PROJECT NAME:  
 BRAKES PLUS - EL PASO COUNTY

PROJECT ADDRESS:  
 2467 MARKSHEFFEL RD

SHEET TITLE:  
 INITIAL EROSION CONTROL PLAN

GRADING AND EROSION CONTROL PLANS
INITIAL EROSION CONTROL PLAN

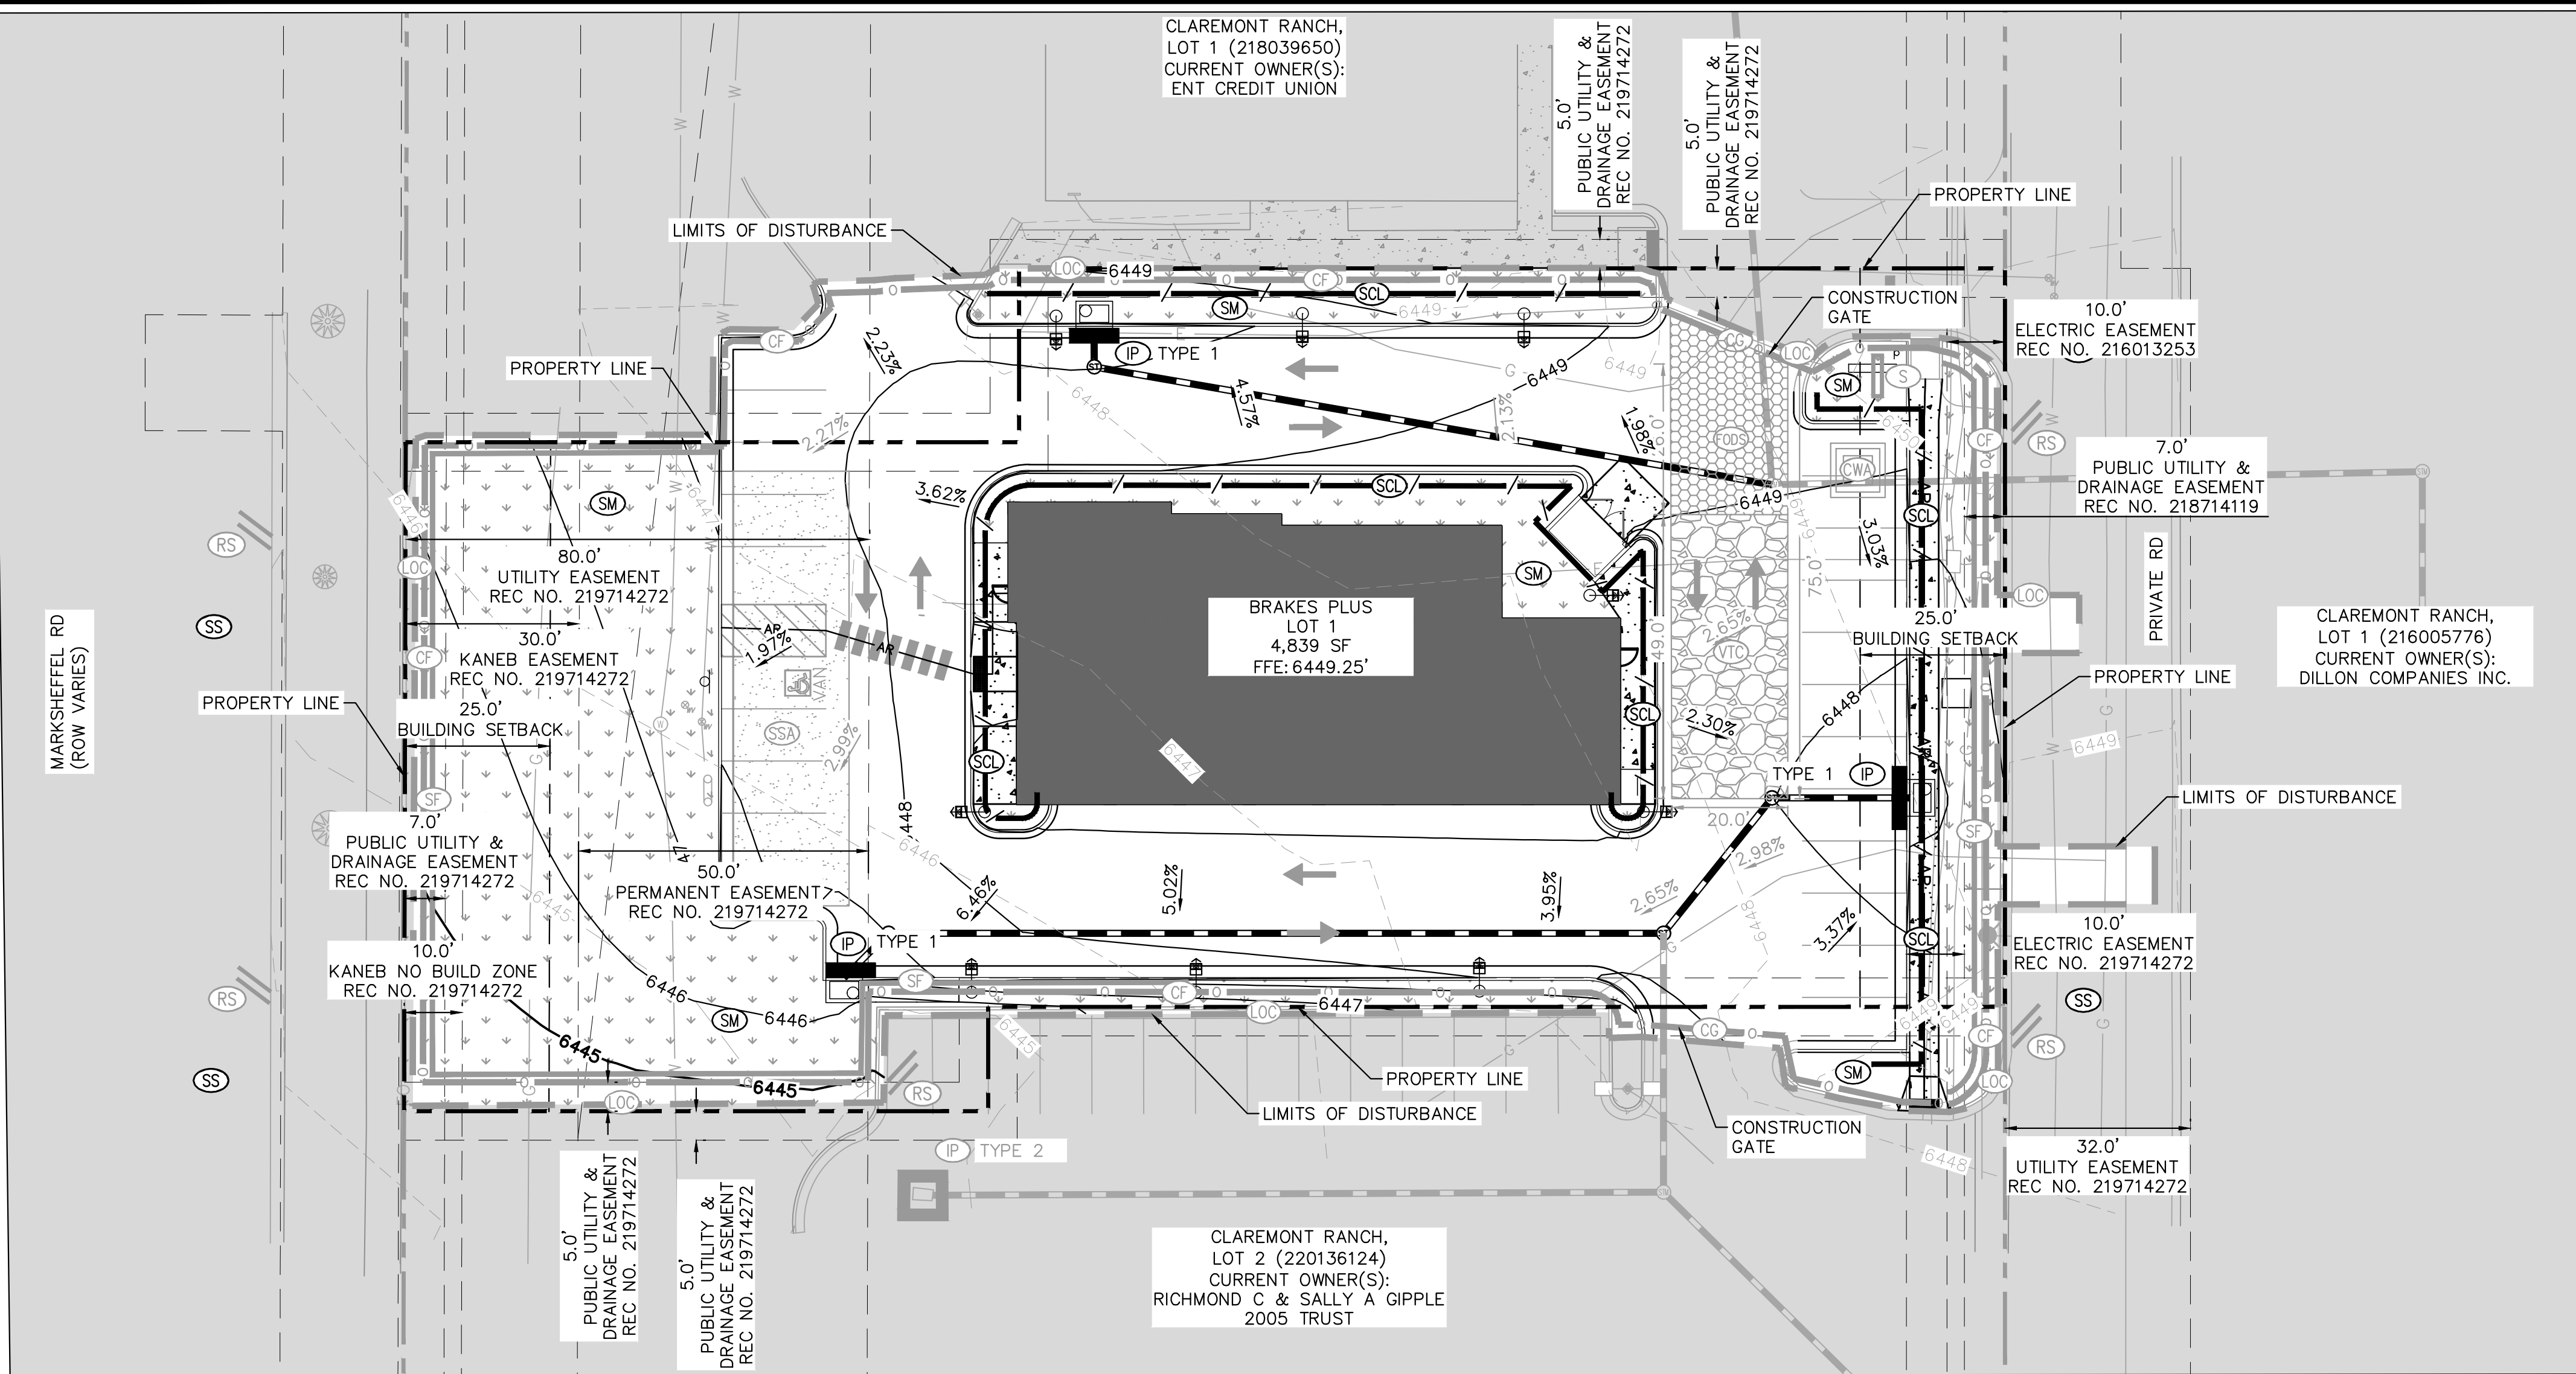
Item H and M. If "limits of disturbance" and "construction boundary" are the same, change to "construction boundary/limits of disturbance" or otherwise show as separate line types for each on the legend and figure.

Checklist Item "I" - add a note about condition of existing vegetation.

GRADING PLAN

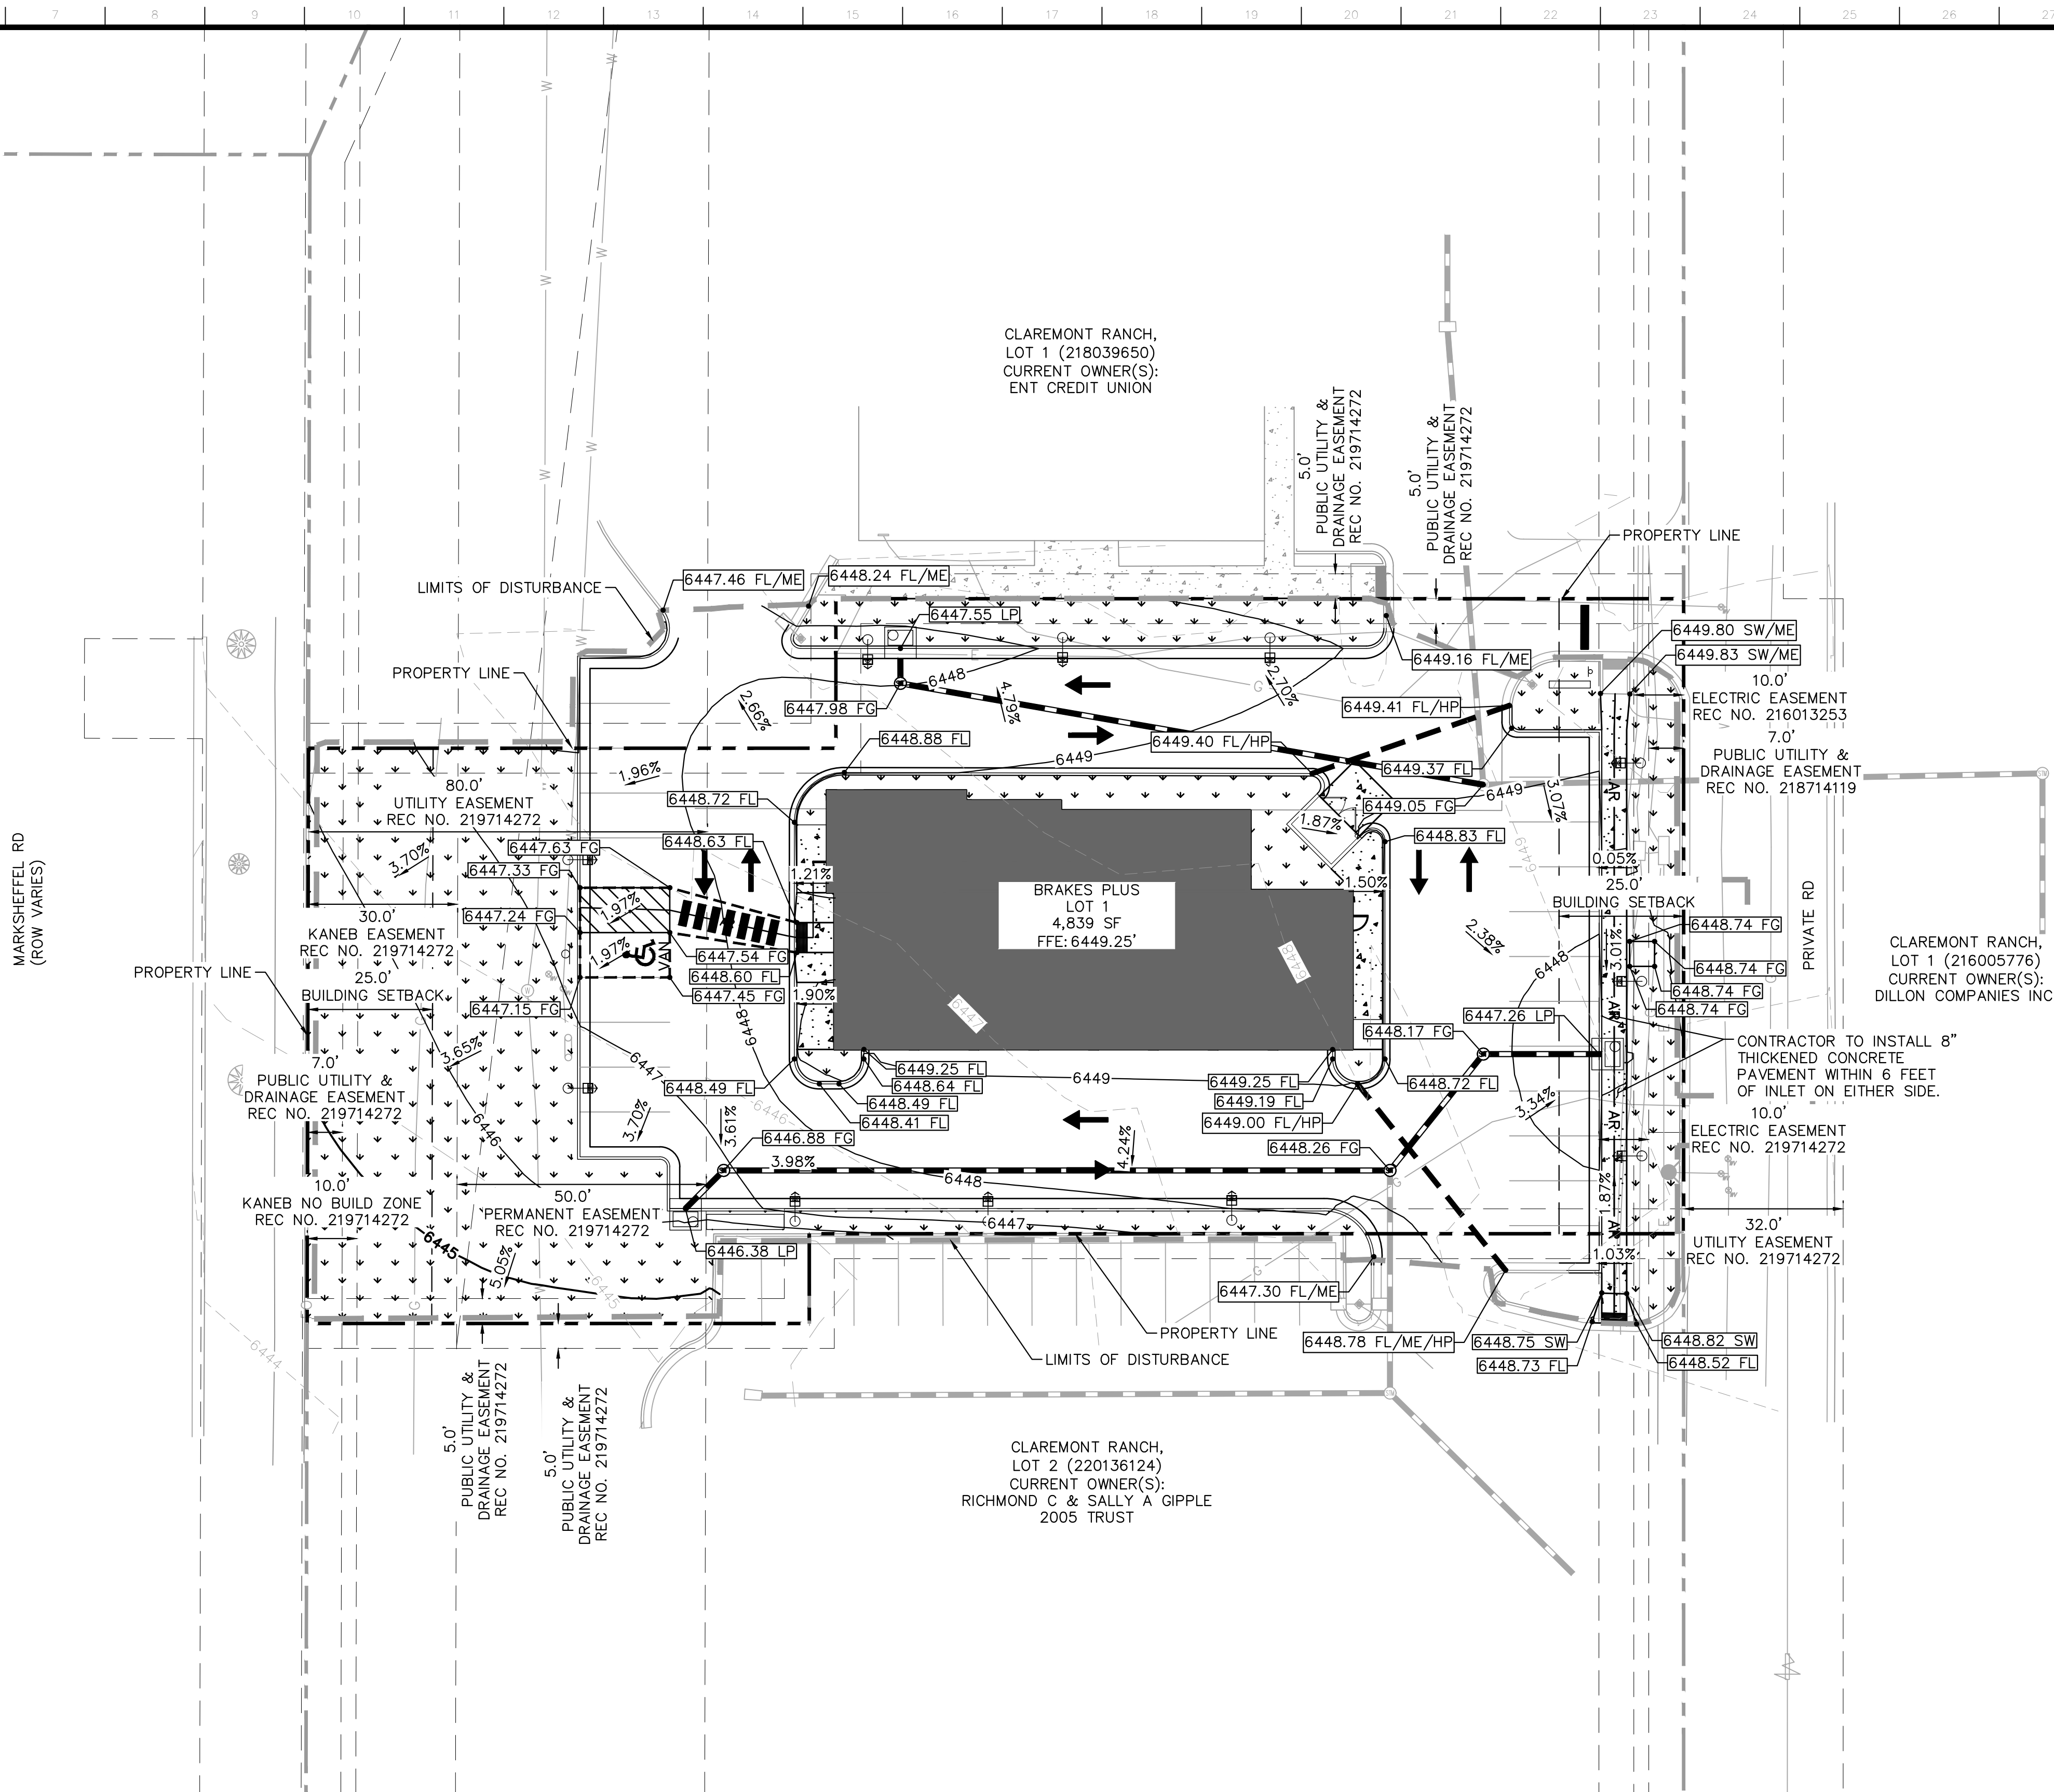
Verify with the County Planner that the proposed layout which eliminates the parking stalls adjacent to ENT is allowed. Site Plan amendment to Lot 1 may be required.

Grading does not meet ADA criteria. Update so it is 2% max any direction within the handicap parking stall.

Divert the sidewalk around the inlet.  
 County is seeing issues of ADA non-compliance where inlets are located in-line of the pedestrian access route.
